WISWELL PARISH COUNCIL

Planning Application No: 3/2011/0714
Non-illuminated sponsorship acknowledgement sign
Junction of A59/A671 Accrington Road Roundabout

Planning Application No: 3/2011/0716
Non-illuminated sponsorship acknowledgement sign
Junction of A59/A671 Whalley Road Roundabout

*RV3 - A59/A671 -
Accrington Road R/but*

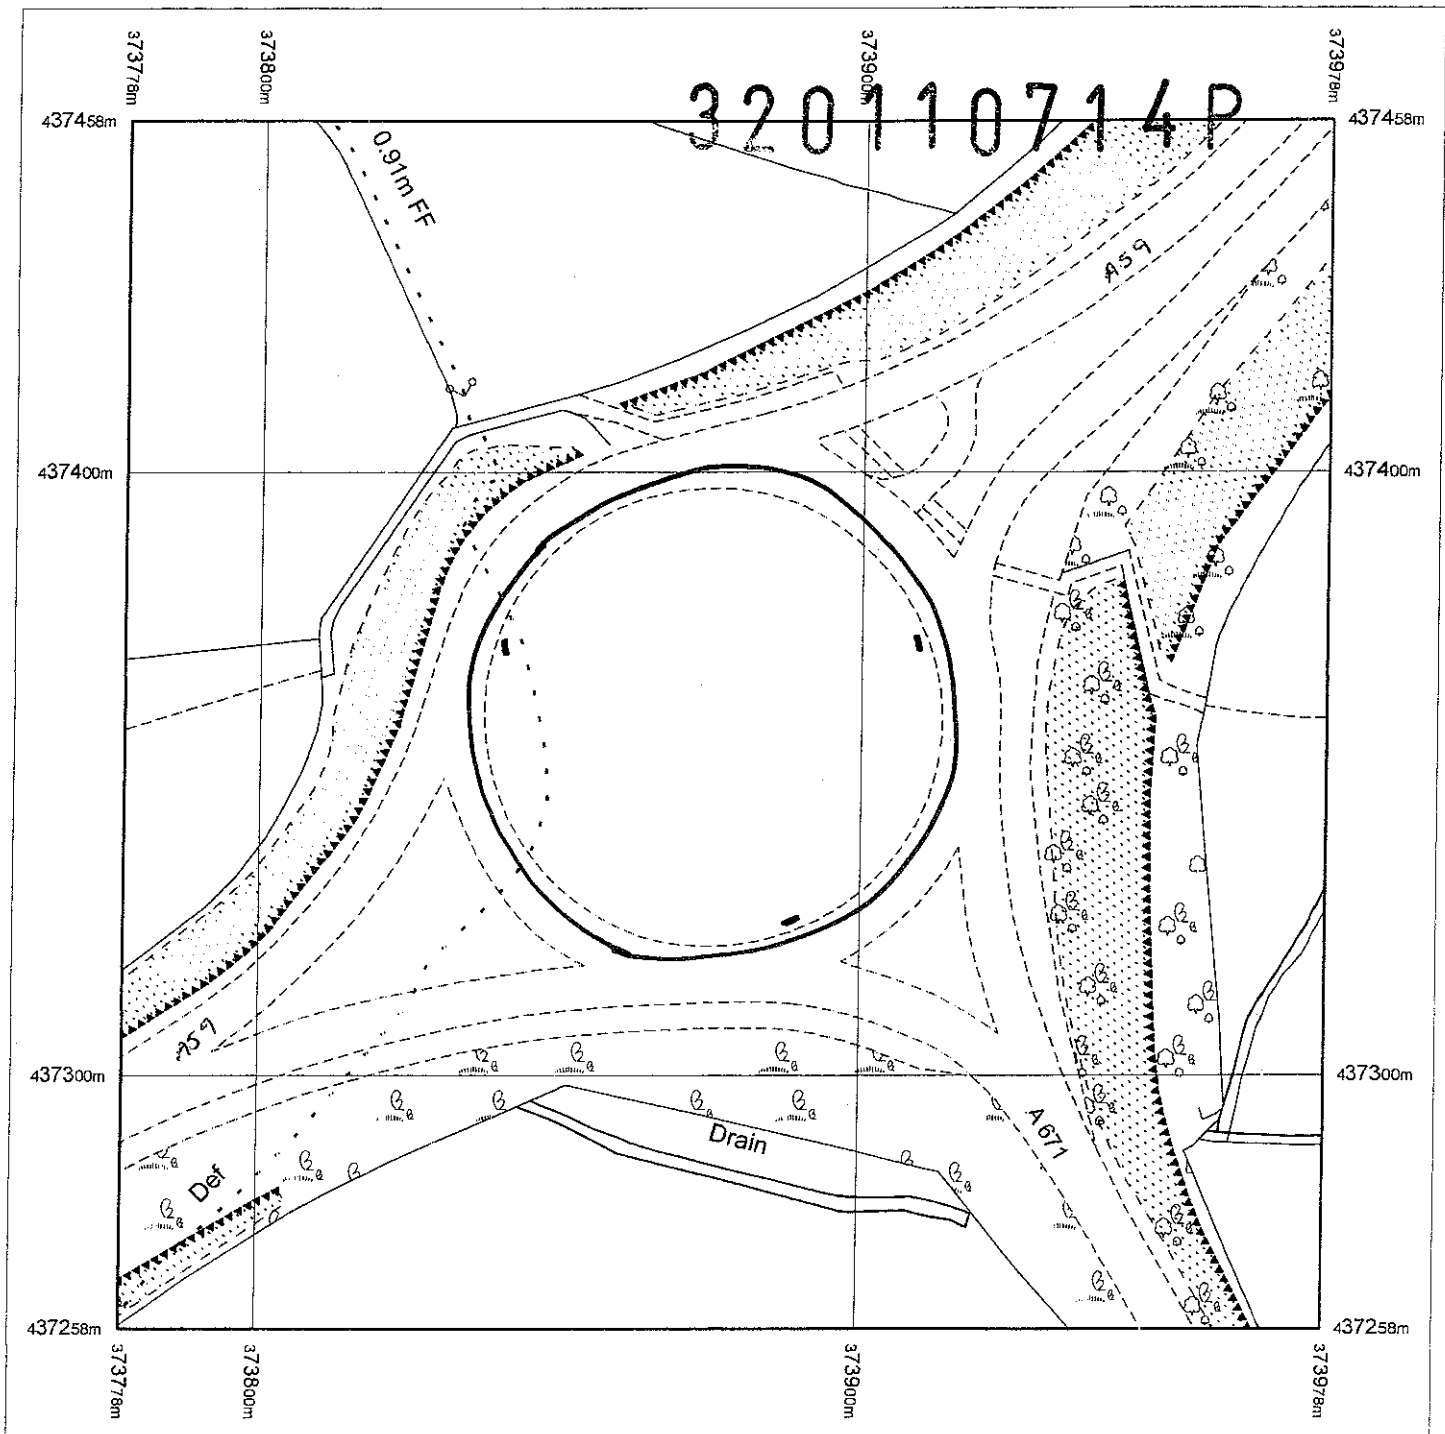
- The signs would cause a serious distraction to drivers negotiating the roundabout, which already has a history of accidents;
- There is already a clutter of signs. Any further would create a visual, unacceptable obscenity;
- It seems inconceivable that the Highways Authority is in favour of such a scheme.
